AT CATHEDRAL PINES D DEVELOPMENT PLAN PRELIMINARY PLAN

ESTATES AT CATHEDRAL PINES
WINSLOW DRIVE
BLACK FOREST, CO 80908
PUD DEVELOPMENT PLAN

SHEET TITLE: PUD DEVELOPMENT PLAN
SHEET NO. 1
1 of 1 SHEETS
FILE NO. PUDSP2210

SHEET TITLE: PUD DEVELOPMENT PLAN

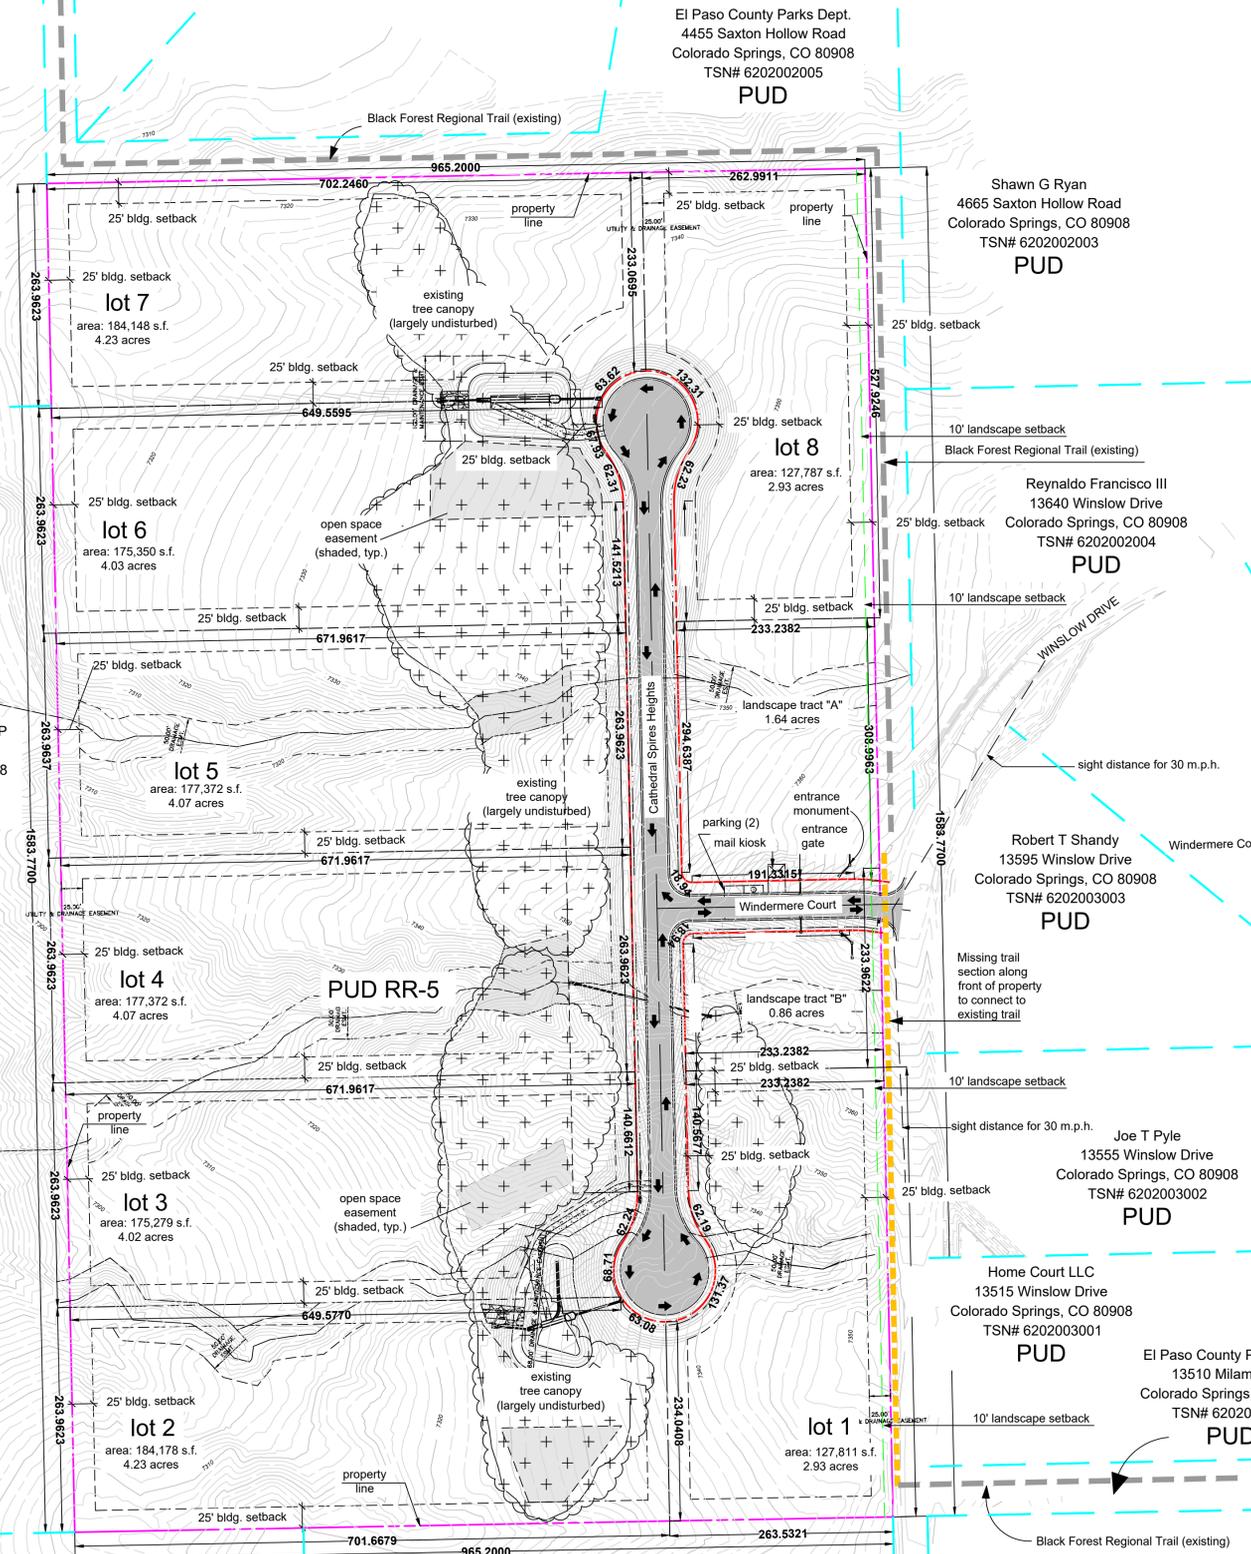
This plan is missing the signature / certification blocks. Please include the following:

Add plan note detailing the ownership and maintenance responsibility of the detention ponds and private road

The ponds cross property lines and are not in a tract. The perimeter easement line need to encompass the pond. Recommend labeling the ponds by letter. The southern pond easement boundary is unclear.

Note needed to explain open space easements restrictions.

label roads as private local class and width

intersection spacing not met. A Deviation will be required. Refer to V4 Comment.

These will not be acceptable as open space. I would recommend designating another open space tract or utilizing the undisturbed treed area as open space. Open space needs to be connected to public facilities so the public does not have to cross over private property to access it.

What does this box + represent?

What is this shaded area?

I'm not sure what this label is intended to convey. The current zoning is RR-5, but the proposed zoning is PUD. I recommend removing this label.
